Our Ref: FG/29/20/PL
Your Ref:

Town & Country Planning Act 1990 (as amended)
Town and Country Planning (Development Management Procedure) (England) Order 2015
Application for Planning Permission

Development Variation of condition 2 imposed under FG/121/18/PL relating to proposed site plan, proposed floor plan, elevations & roof plan.
Location Onslow Caravan Park Onslow Drive Ferring

DRAWING TITLE	Proposed Site Plan
DRAWN	SCB
JOB NO	031
DRAWING NO	03

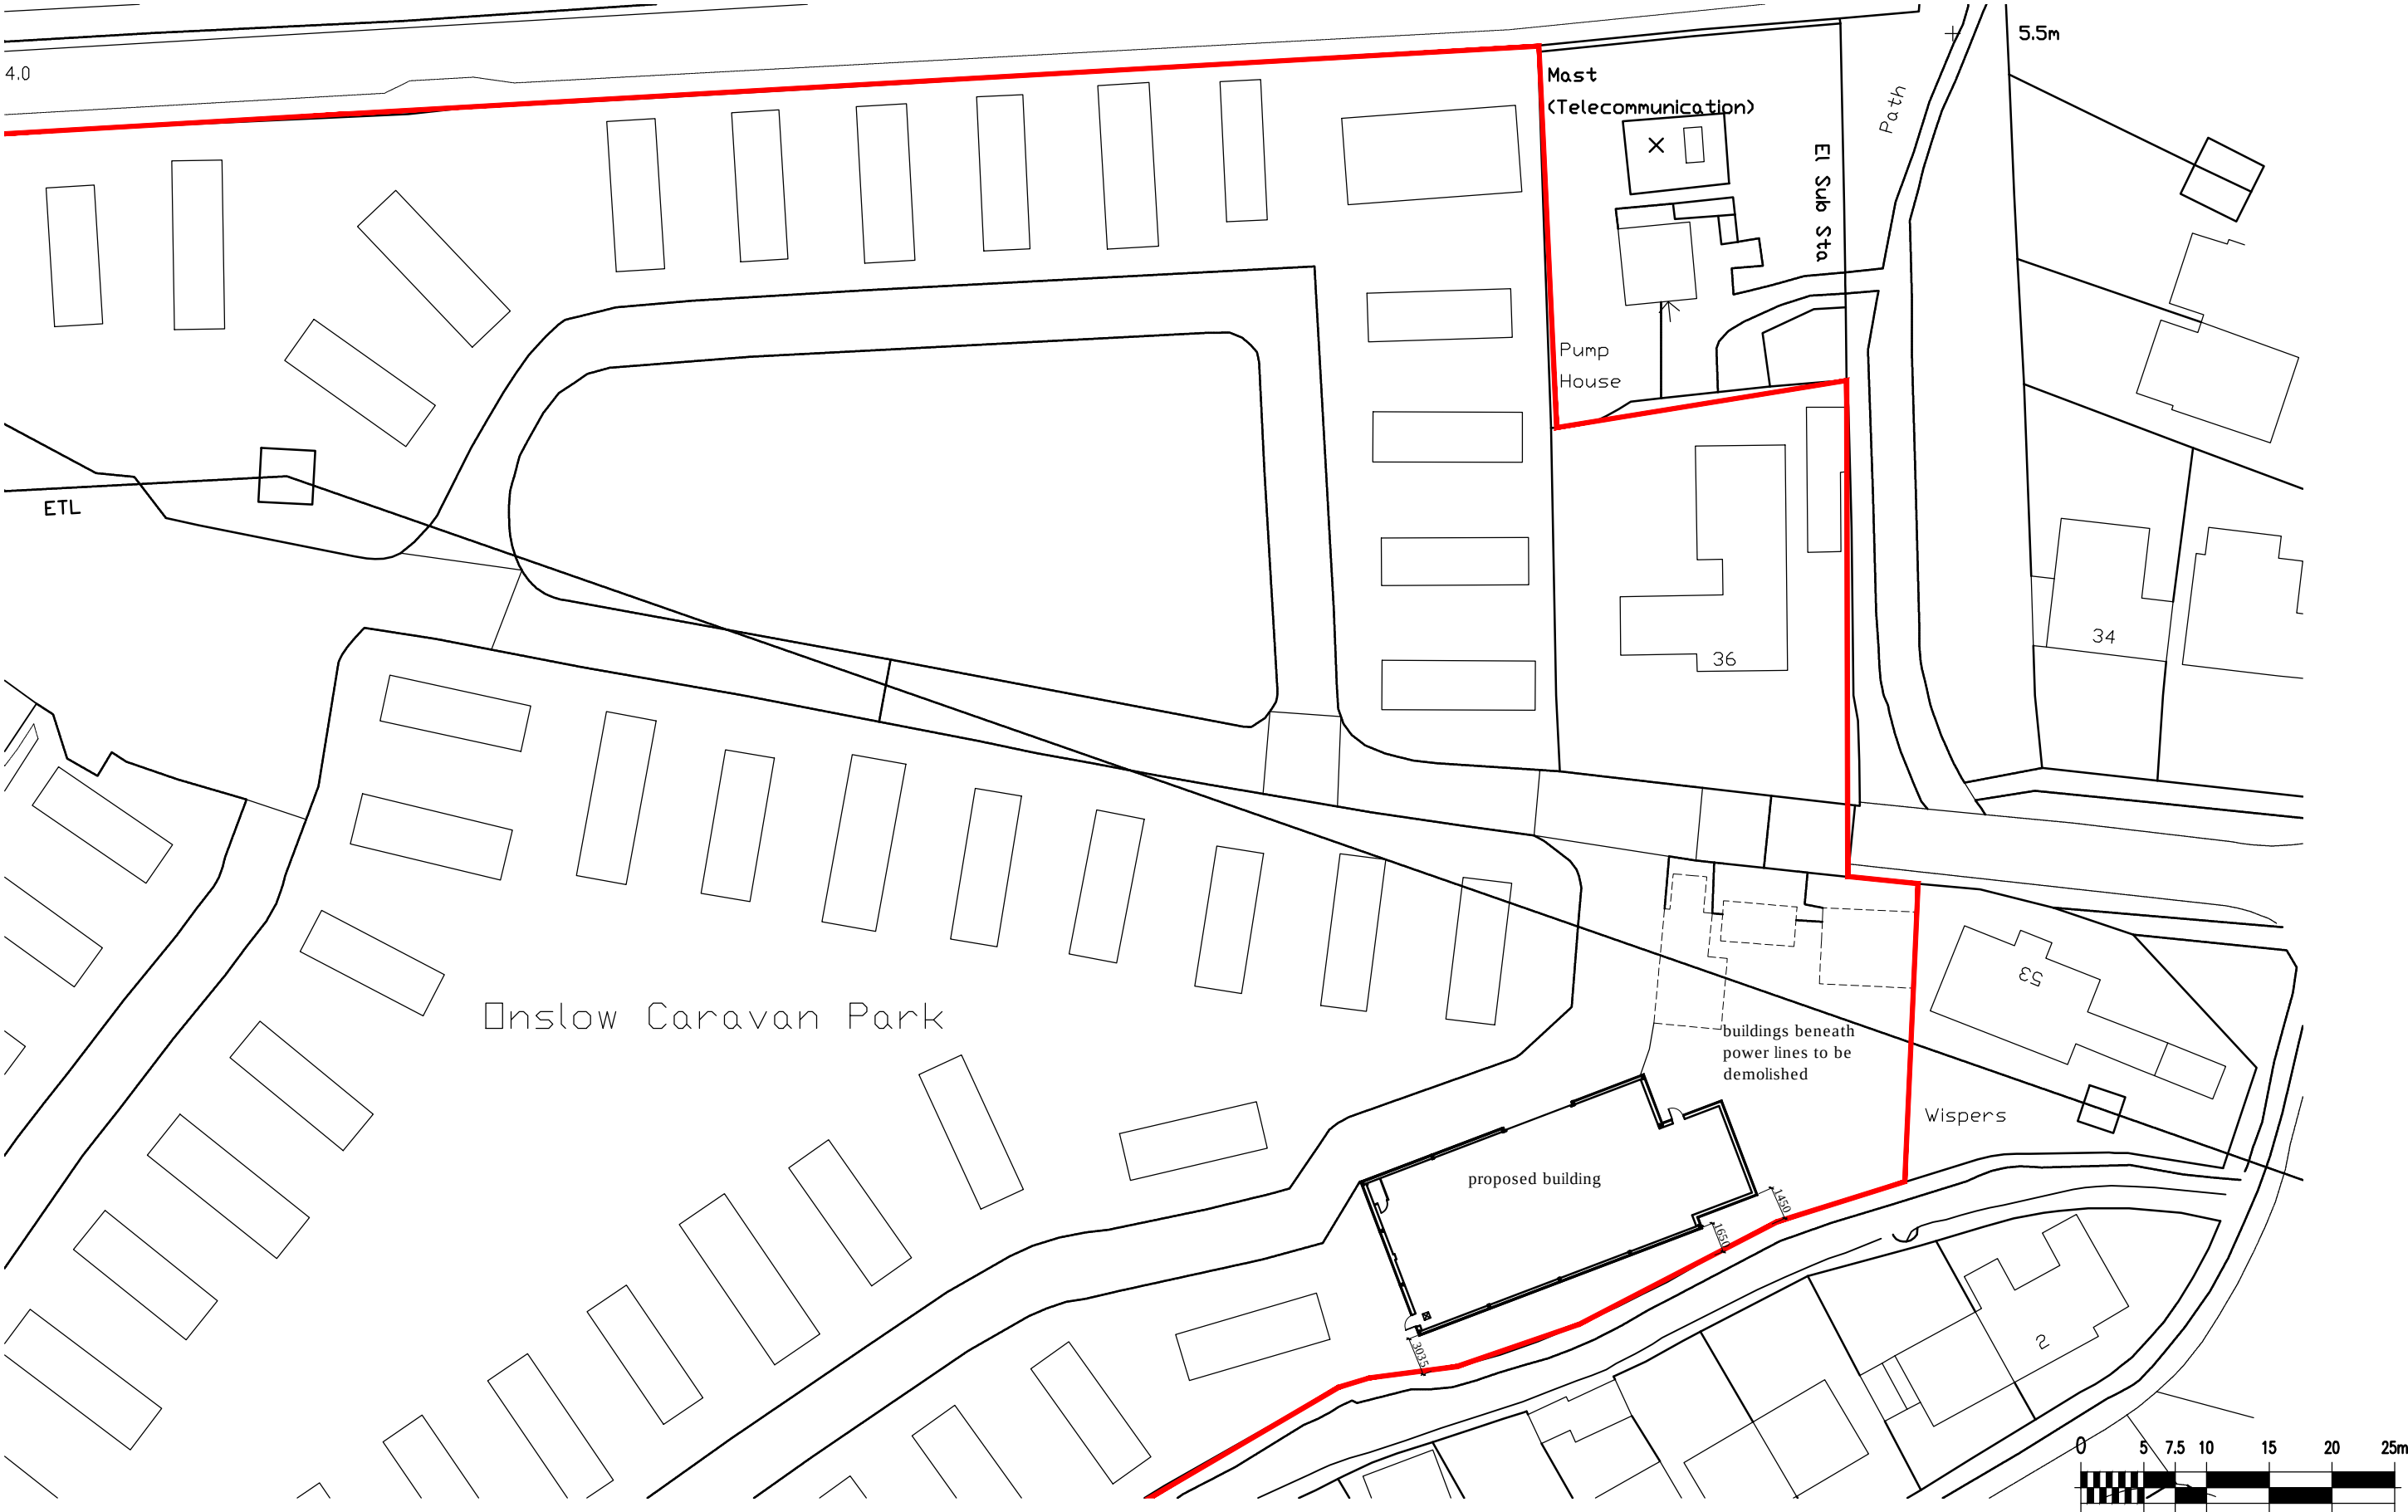
Please provide a revised site plan to specify exact measurements from the SE and SW corners of main building to southern boundary.
